**Patterson Britton  
& Partners Pty Ltd**

## **SURVEY STREET, LENNOX HEAD – WATER MANAGEMENT**

This letter addresses the water management issues raised in the Department of Planning (*DoP*) letter dated 4 December 2006 and the related submissions with respect to the Environmental Assessment for the above residential subdivision.

COASTAL GROVE
RAINGARDEN CONCEPT

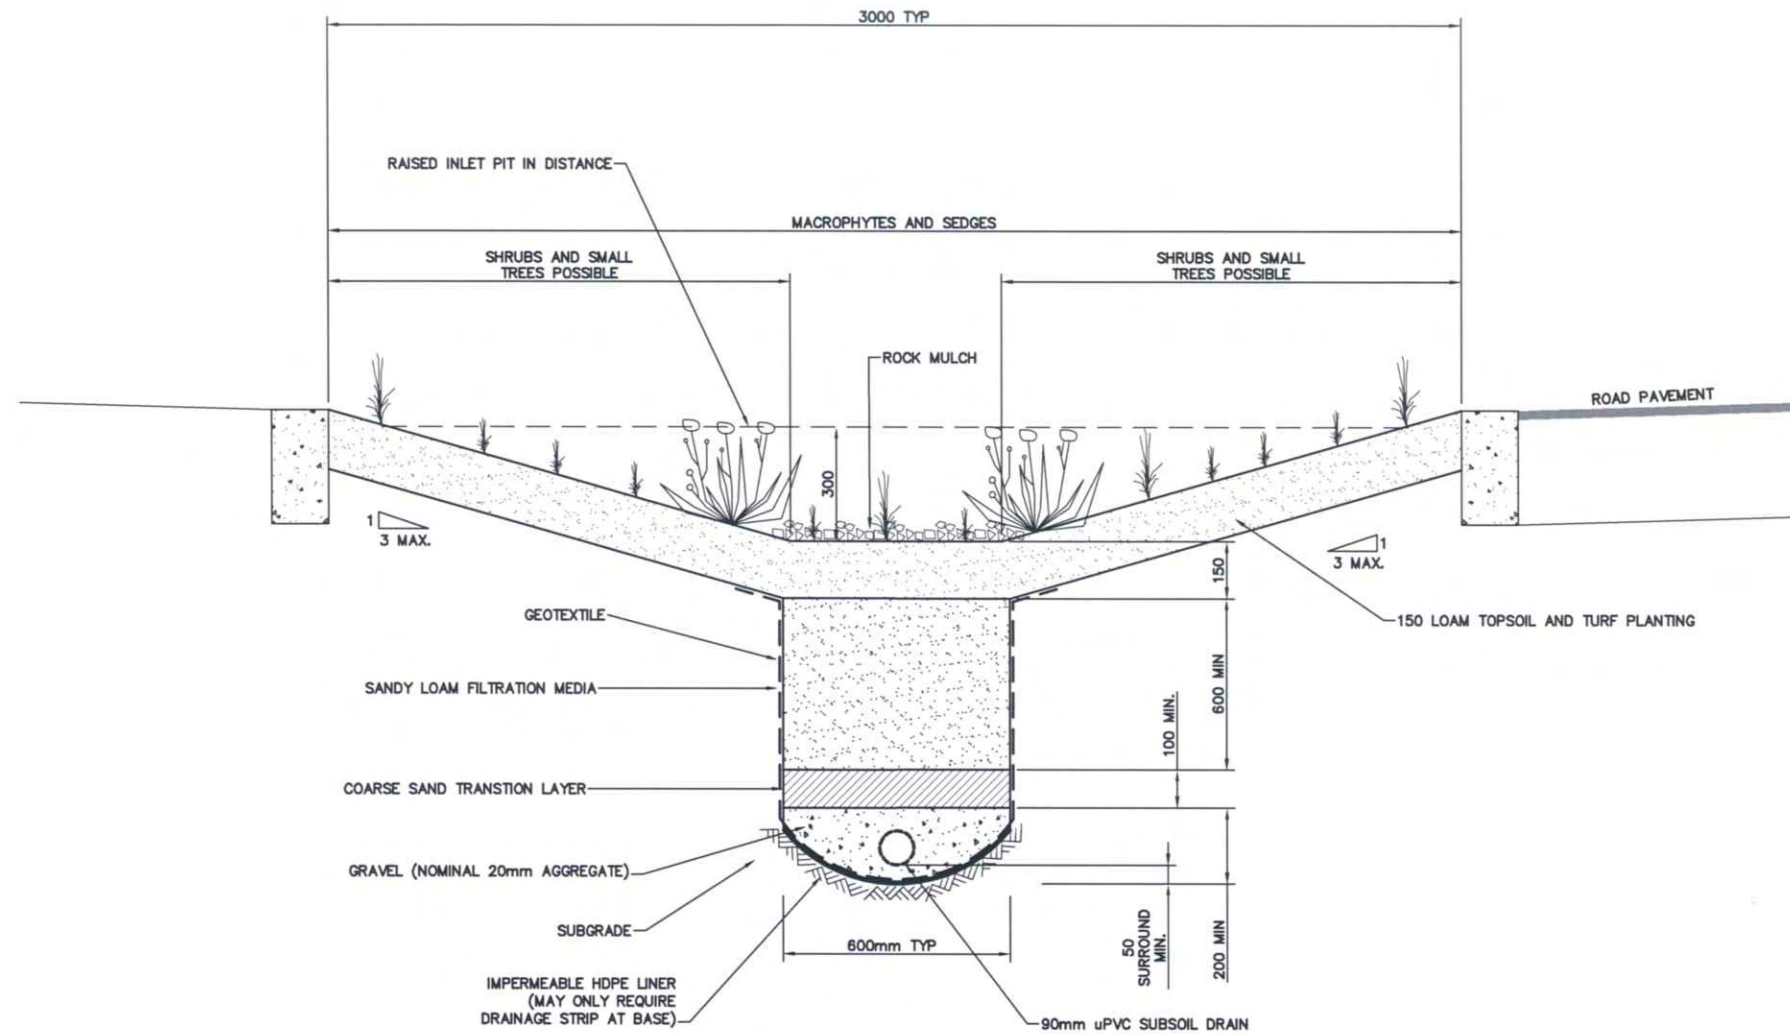
4. The base of the raingardens would be located above the groundwater level and their performance would not be adversely affected due to groundwater. The raingardens provide their own drainage media for filtering runoff and do not rely on infiltration into the surrounding subsoils.

5. Penetration of tree roots through the geotextile layer would not present a significant problem for operation of the raingarden. The impermeable liner is not required for this site and could be deleted.

TYPICAL SECTION THROUGH INFILTRATION TRENCH

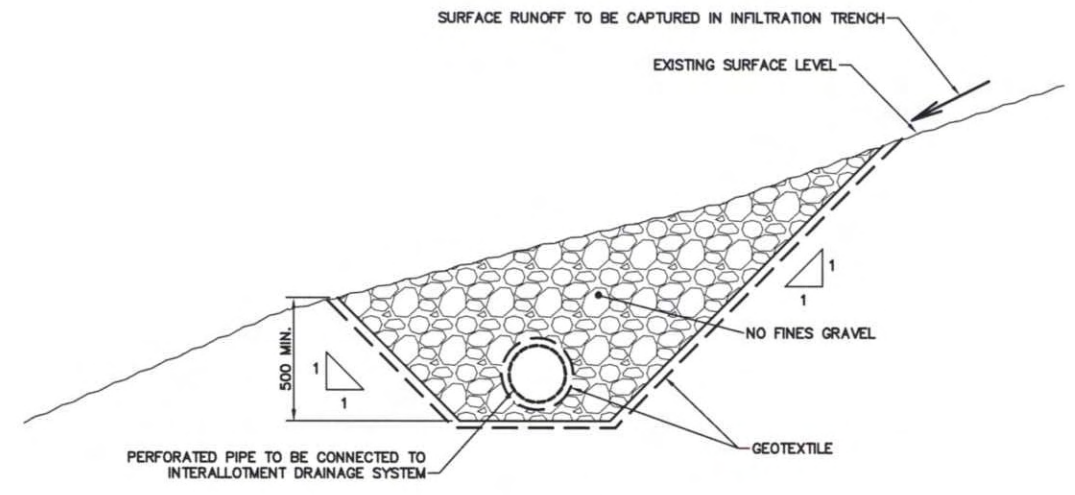
1. The runoff collection drains (*previously called infiltration trenches*) would not promote infiltration into subsoils. They will direct collected surface runoff into the interallotment pipe drainage system. Runoff from houses and paved areas will be discharged directly to the interallotment pipe drainage system not to the runoff collection drains. Coffeys have confirmed that this drainage system would not adversely impact on slope stability.

3. The trench drain capacity to accommodate seepage would not be reduced by the runoff collection drains. The flow in the runoff collection drains would discharge to the interallotment pipe drainage not the seepage trench drain. The two systems would be separate elements.
